Maritime &
Coastguard
Agency

Your ref: **20012643**
Our ref: Thanet Extension Offshore
Windfarm Project (EN010084)

5 February 2019

Thanet Extension Offshore Windfarm Project (EN010084)

Figure 10.2

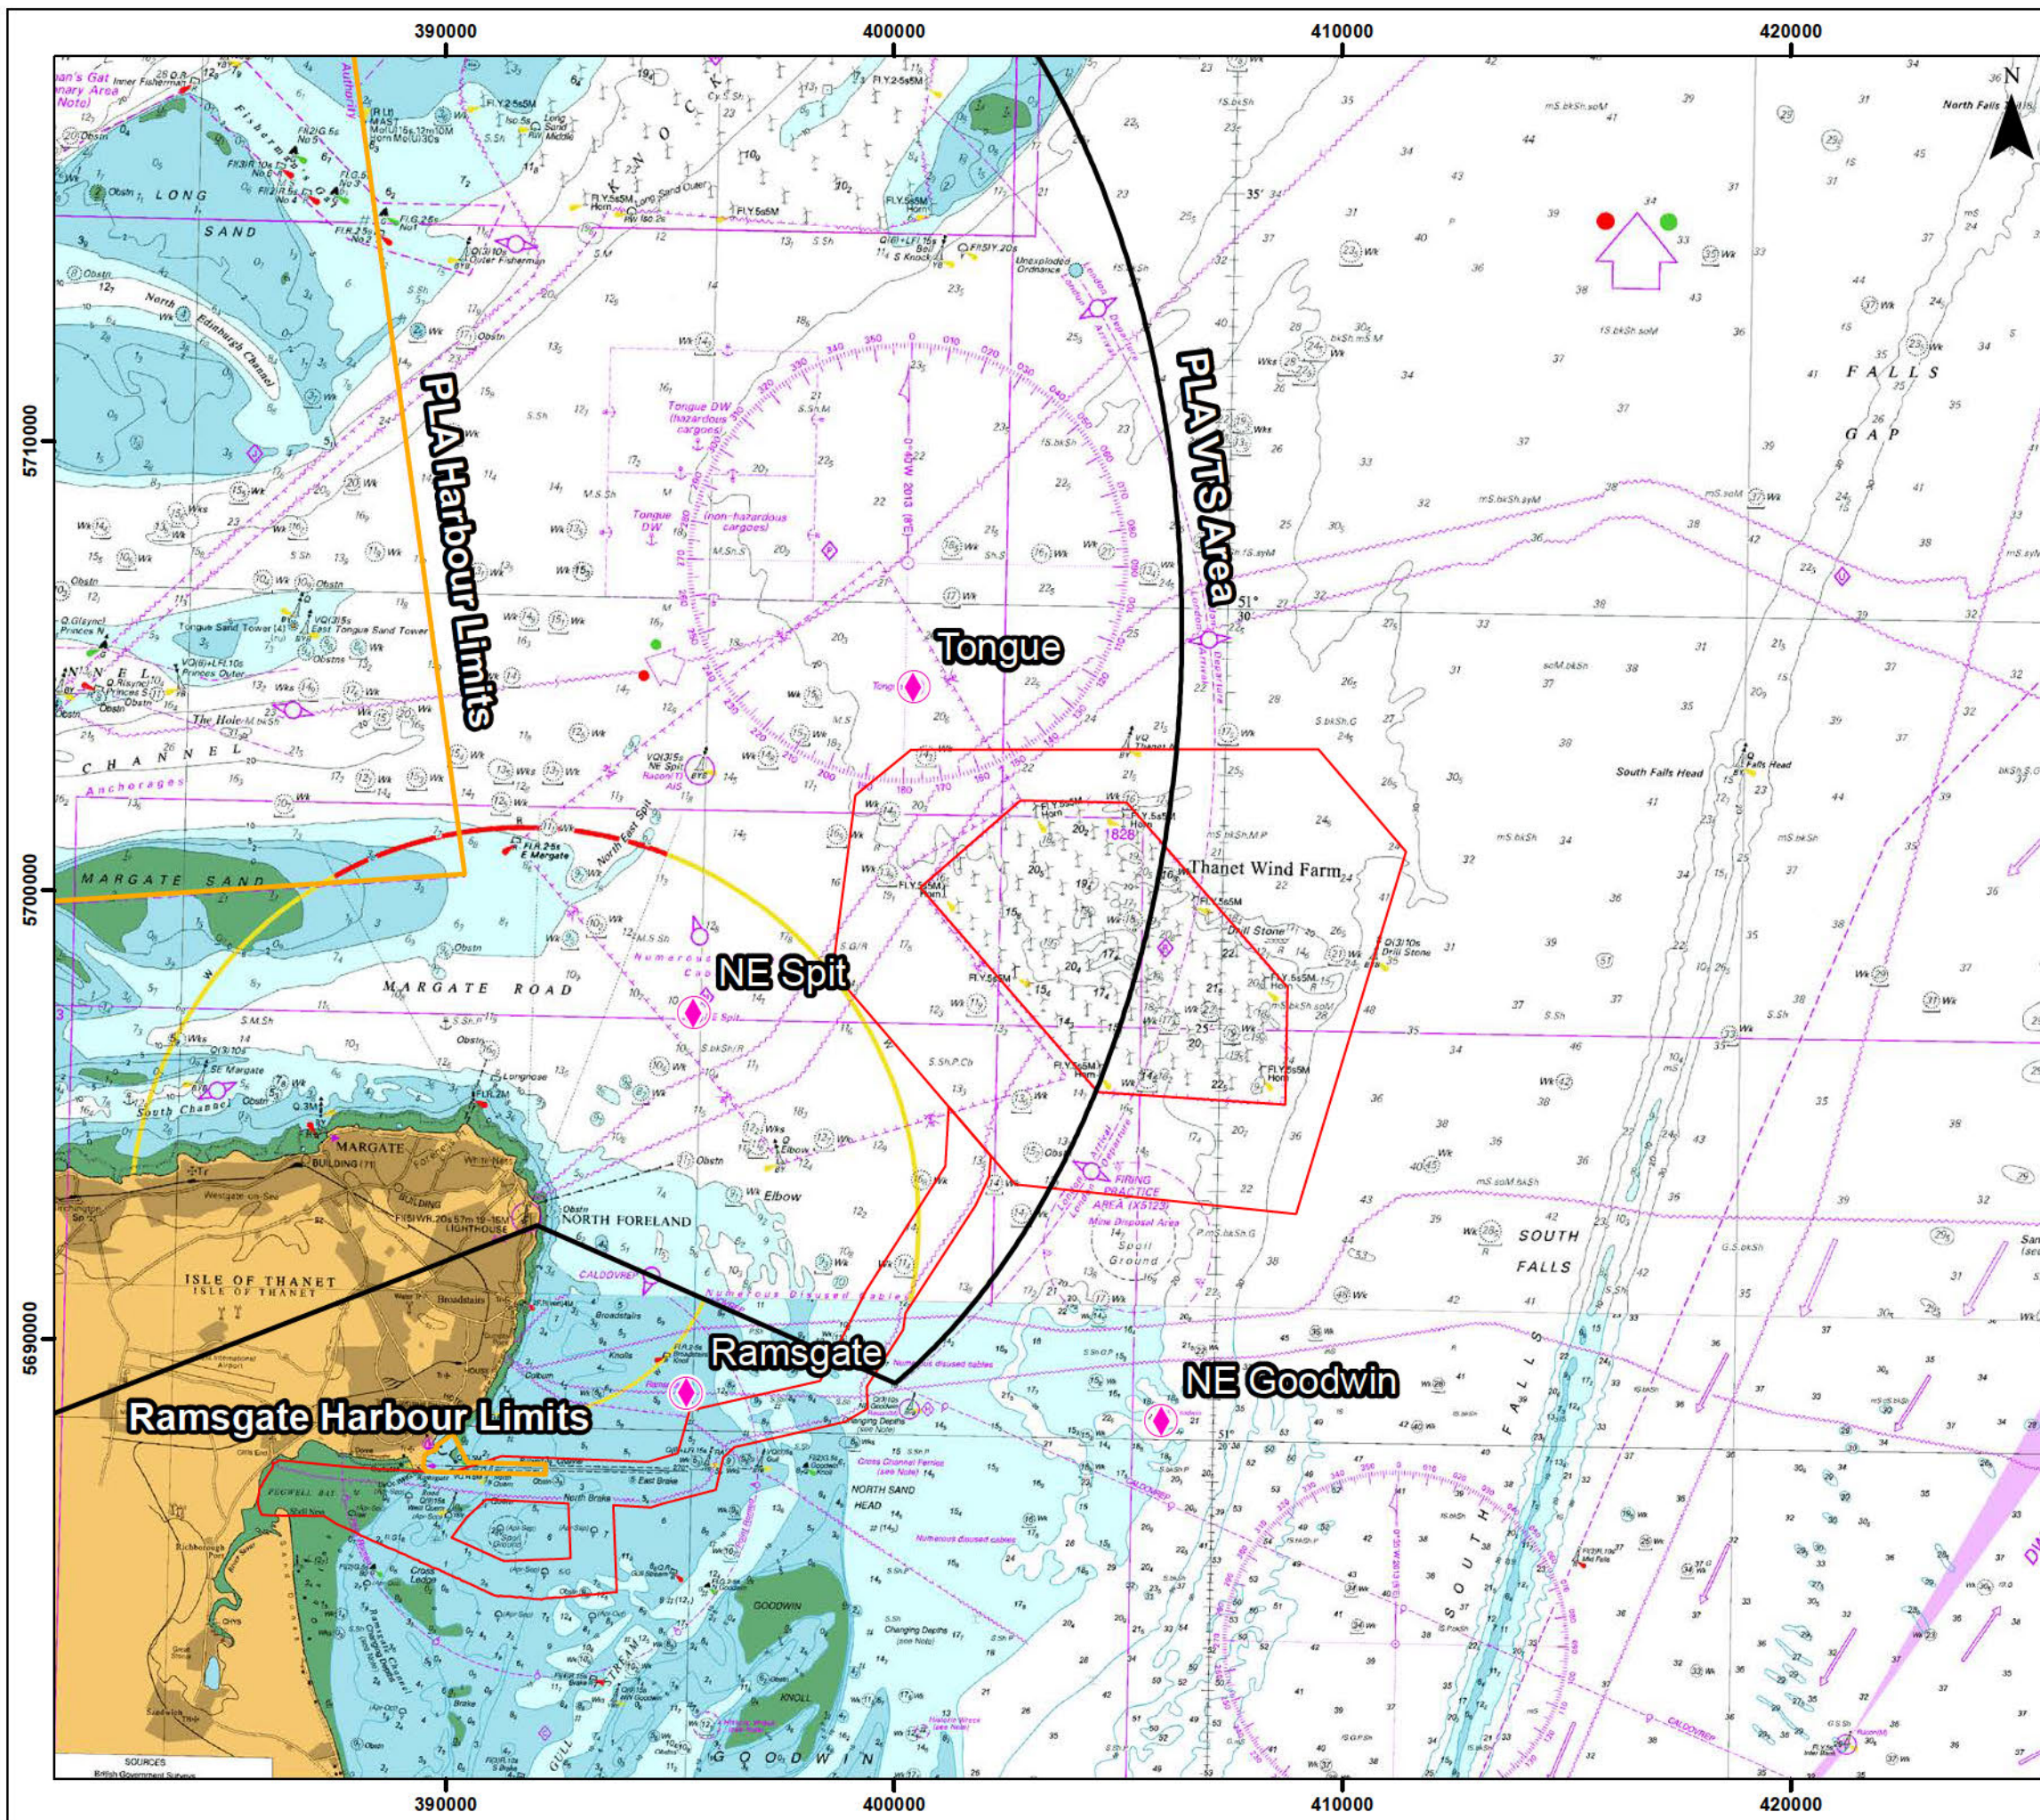
- 1) The expansion of the windfarm will constrict the number of vessels and constrain their available sea room considerably. Vessels embarking pilots need to steer a particular course (to create a Lee for the pilot) and keep a minimum speed (usually of 6-8knots speed). This consequently results in vessels steering at the windfarm at speed. Naturally at present, with the available sea room, this is possible and deemed safe, but will not be possible after the expansion in way towards the pilot station.

4) If the NE spit pilot station had to be relocated further seaward, this will unfortunately result in extra costs, not just financially, but also in time, to pilots, and pilot launch transiting times. Being exposed further out to sea, may also have the result of more probable likelihood of unfavourable sea and swell conditions.

Figure 10.11

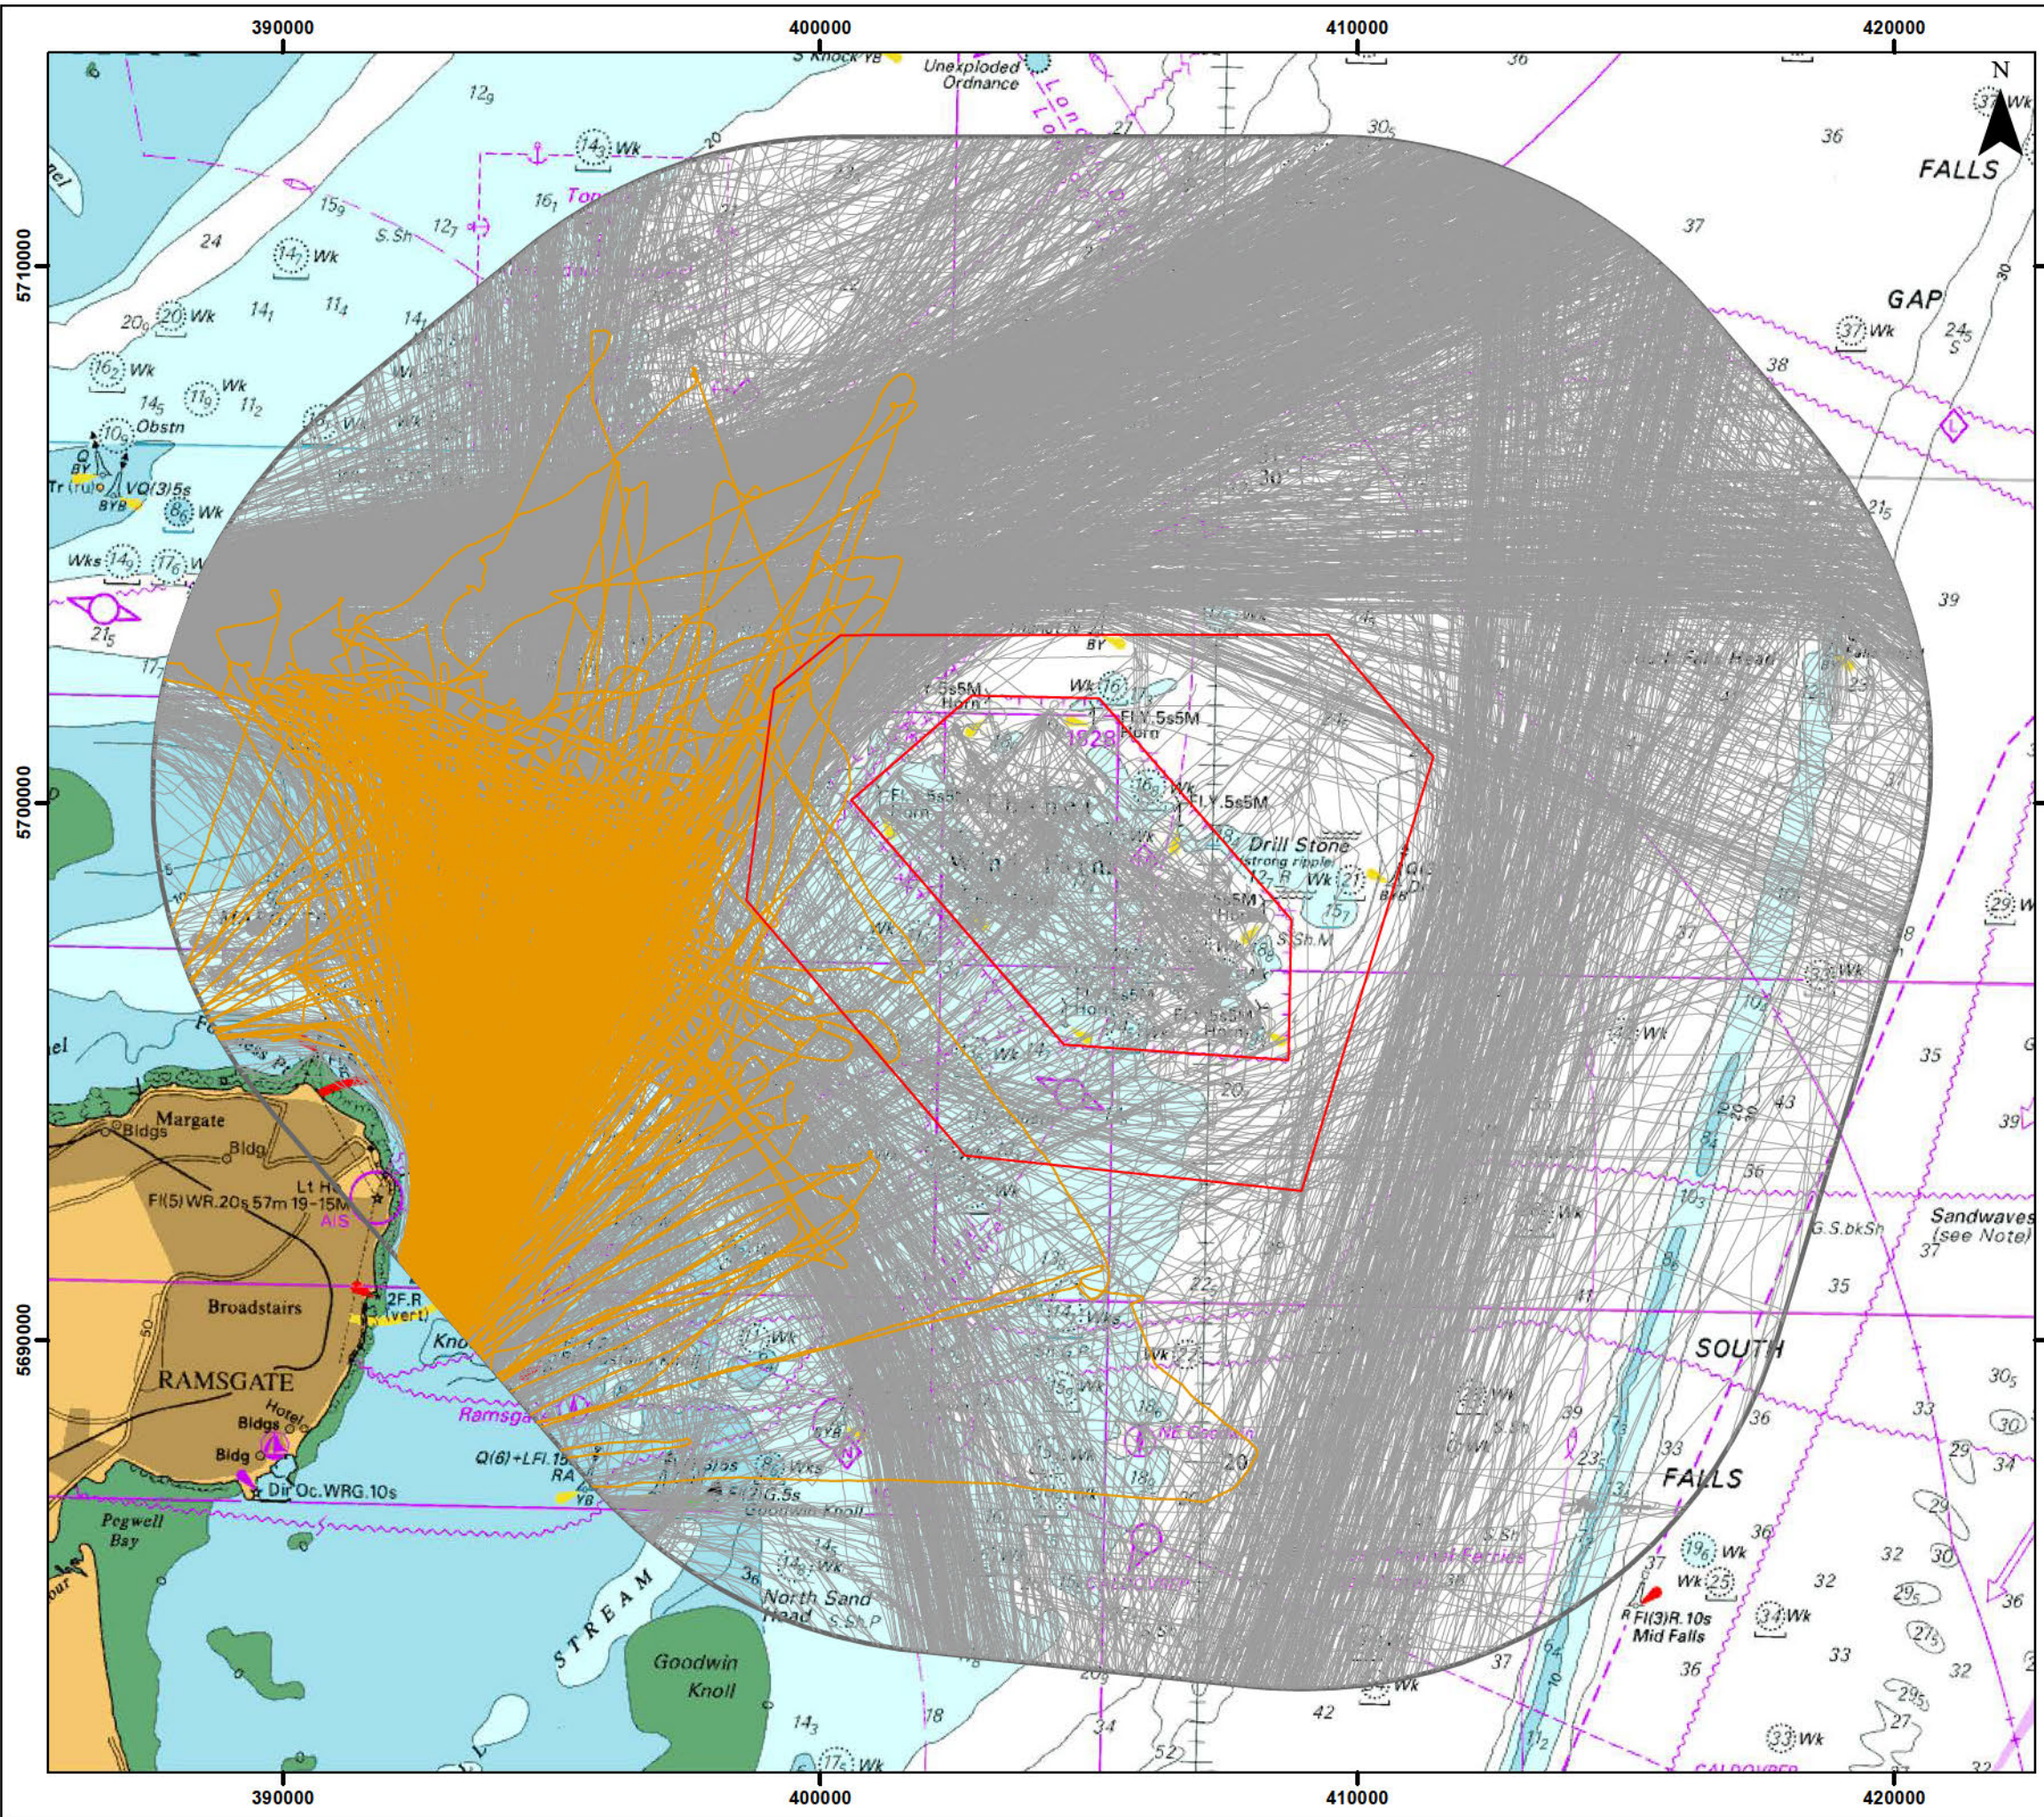
- 3) There are concerns that simulations and discussions had only taken place with experienced pilots of this area. A master of a vessel who has never been to the NE spit (large or small vessel), will be very much more concerned and warier of transiting the area.
